EPC STORMWATER REVIEW COMMENTS
IN ORANGE BOXES WITH BLACK TEXT

UDON SOUTH SITE DEVELOPMENT PLAN 12265 HIGHWAY 94

SITE PLAN
SHEET 3 OF 20

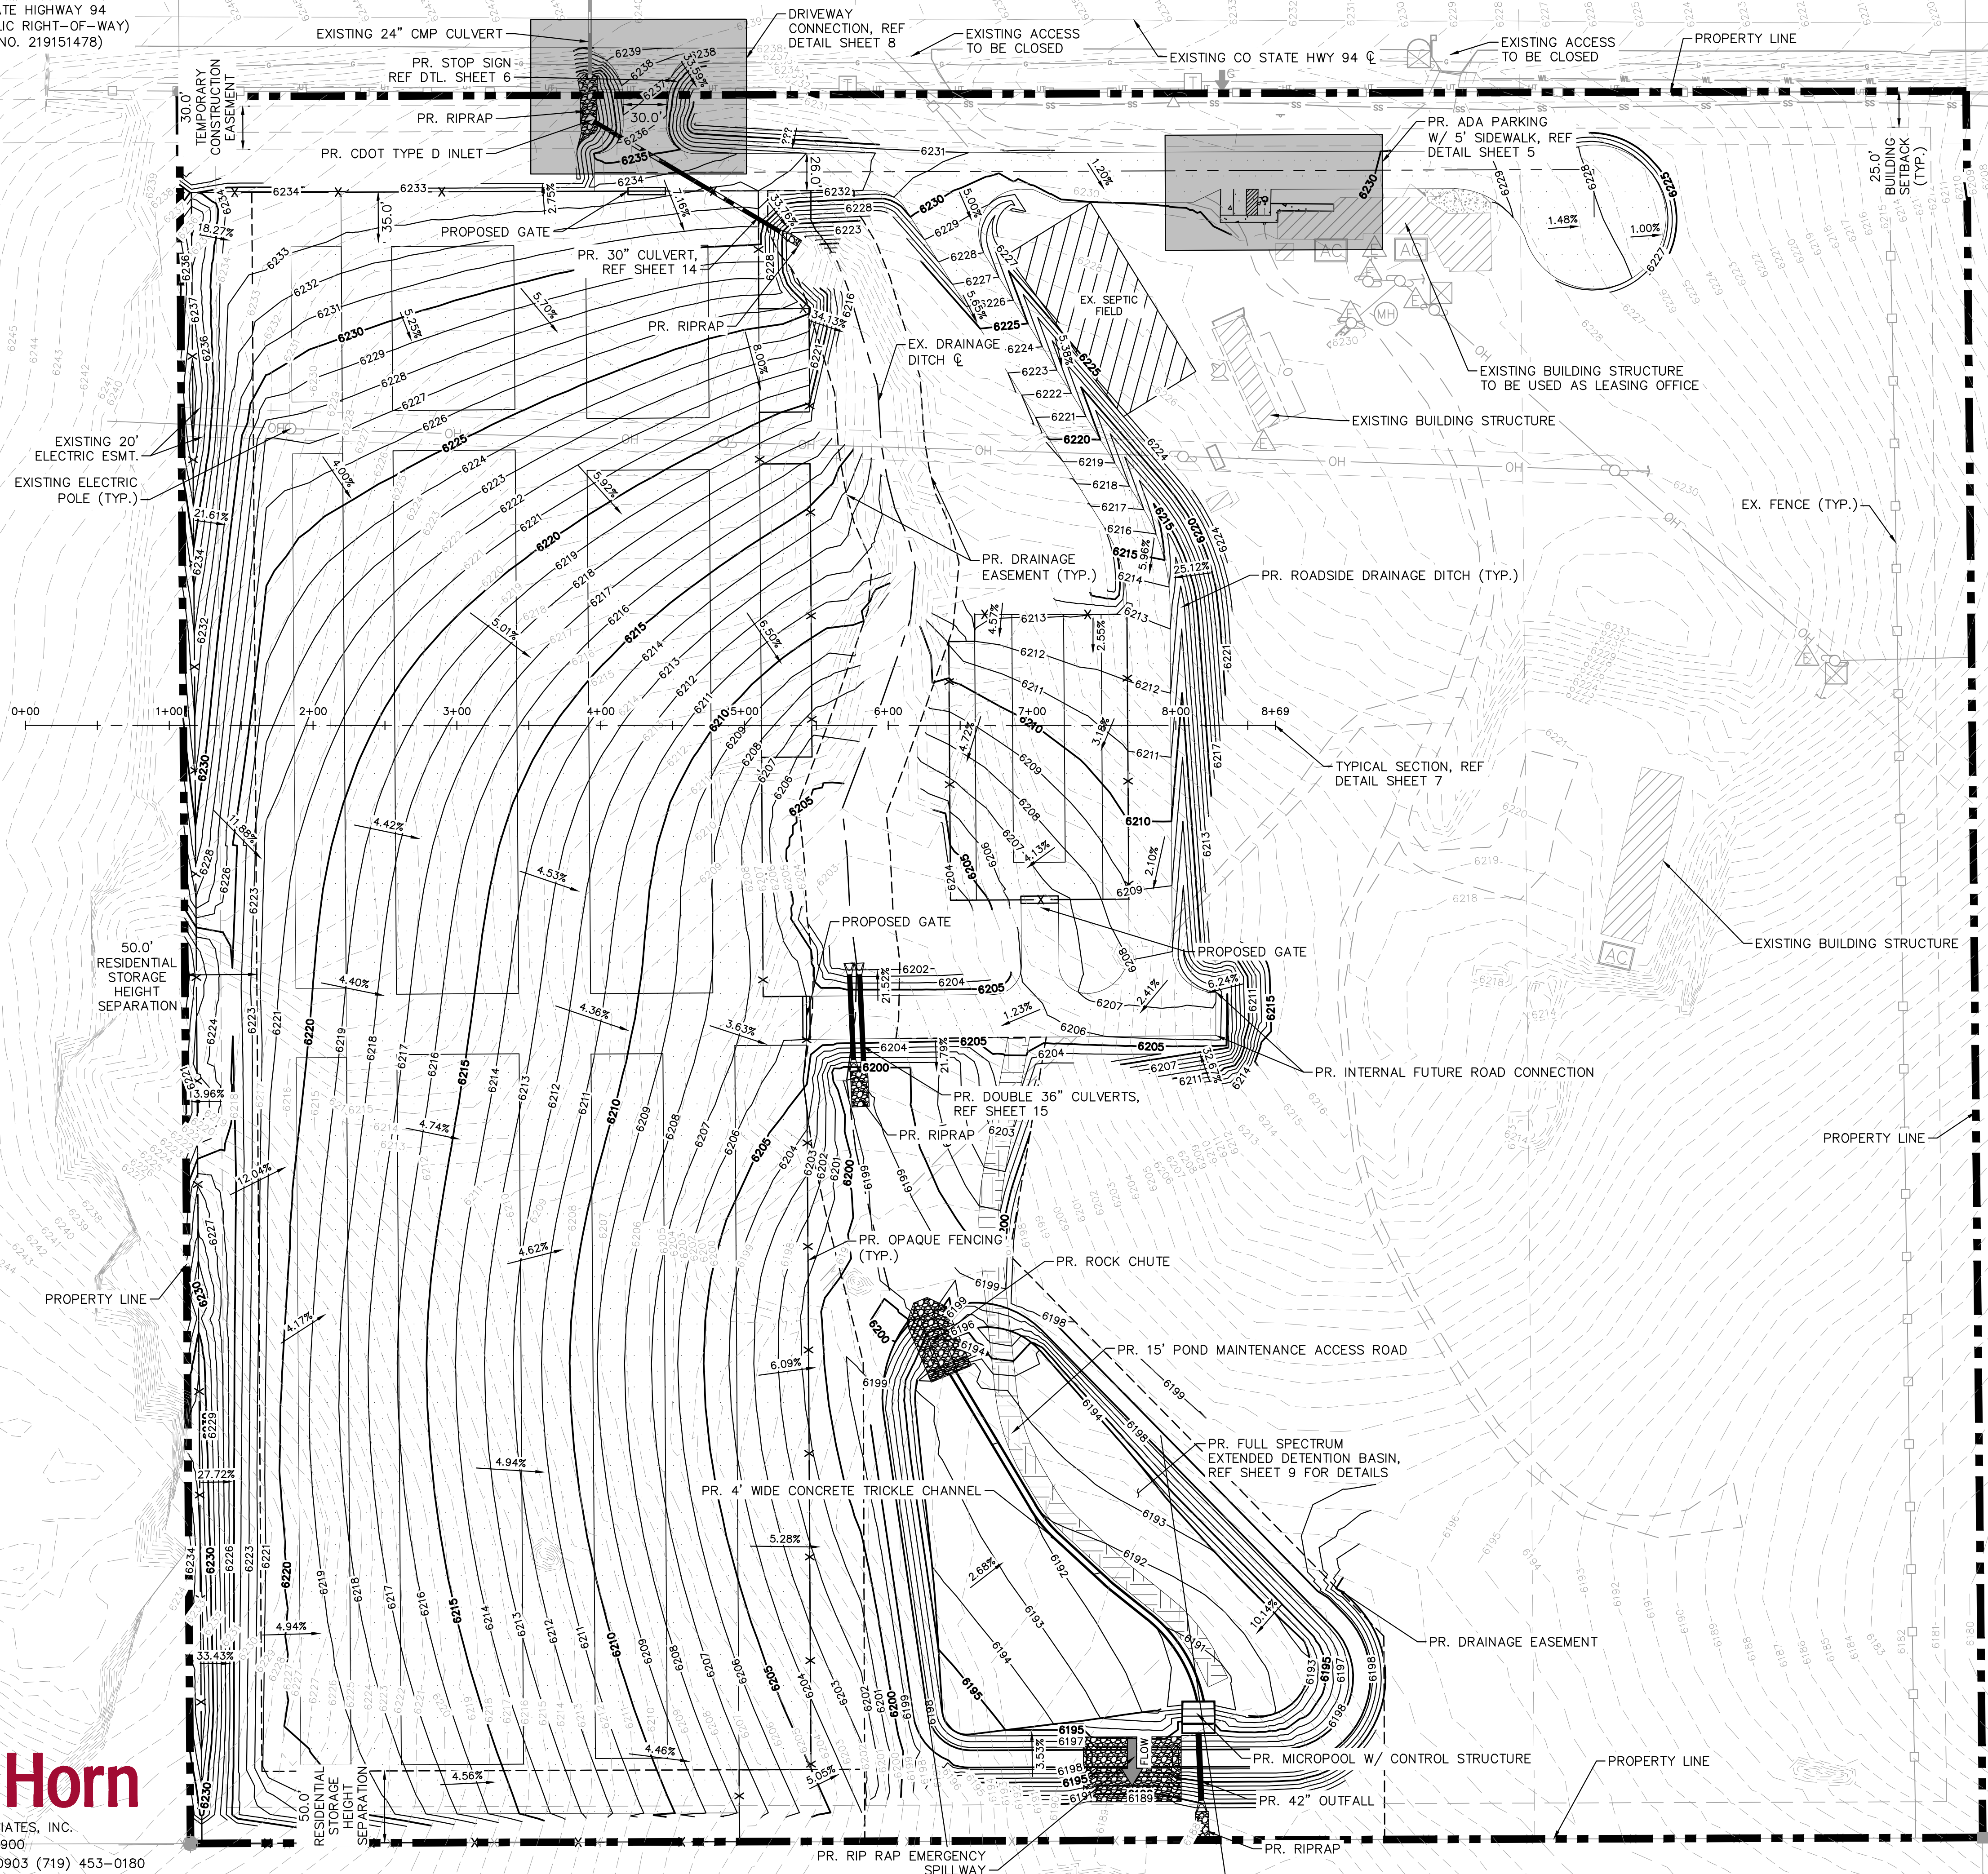
The first 50' off of Highway 94 shall be paved with asphalt, concrete, Modular Porous Block Pavement or the equivalent.

Depict all existing or proposed easements.

Refer to the comment letter provided by CDOT for required future road expansion.

Dimension the setback from property lines to all existing buildings.

Add location of all (proposed) berms.

Provide location and dimensions of all signage to be proposed.

Provide location and elevation of dumpster enclosure. §6.2.2.G.1.b

Coordinate with the Traffic Engineer to provide recommendations for the location of the gate to ensure that the vehicles do not stack into Hwy 94

Outside storage shall be enclosed and concealed by a solid fence or wall at least 6 feet in height or any combination of berming, shrubs, trees fencing or walls which will provide at maturity a minimum of 6 feet of height and 100% opaque screening for the area utilized for outside storage.

Add line work for spaces
The TIS shows much more detail
Delineate stall size within the large parking area.

This does not match LOI which says 1000 parking stalls or the TIS which has 860. The TIS has 860 for the UDON South development and 1000 for the UDON north.

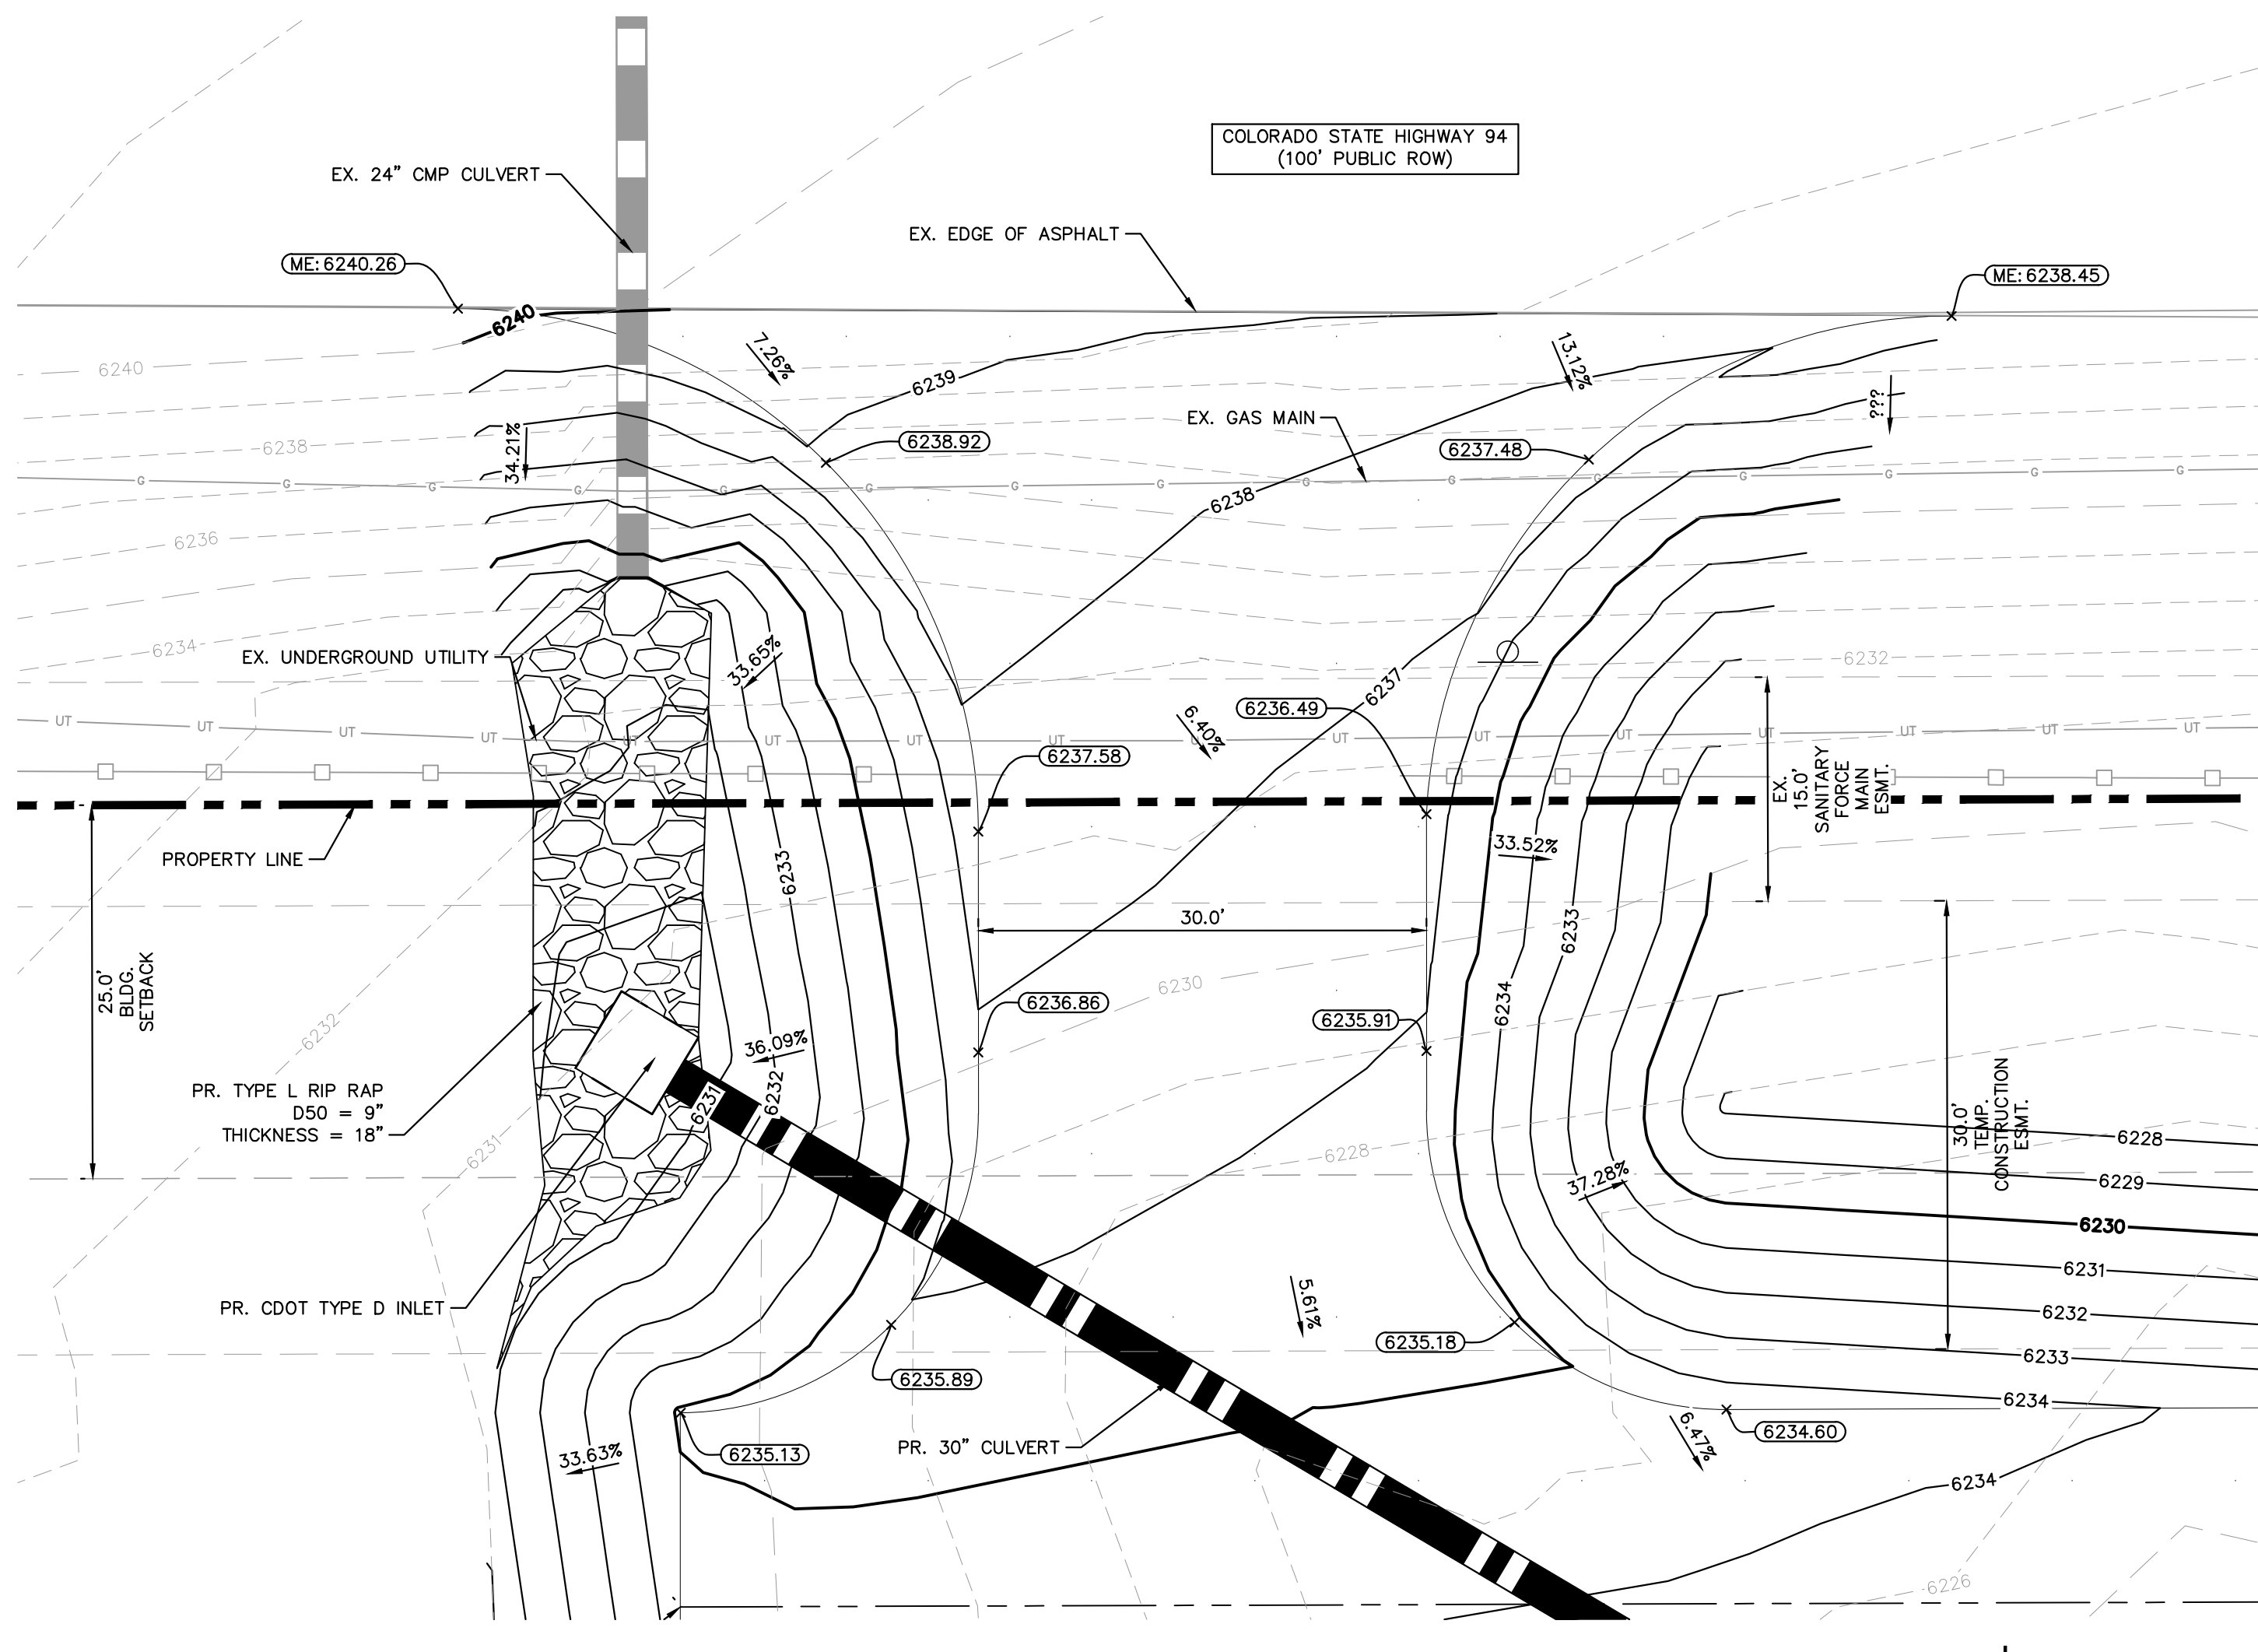
Coordinate with the Traffic Engineer so that recommendations can be provided for the turn radius of the Driveway for the proposed RV design vehicles. Auto turn exhibits should be provided.

Provide CDOT standard for access. This would be for a residential driveway to a local not a commercial access to an arterial/highway.
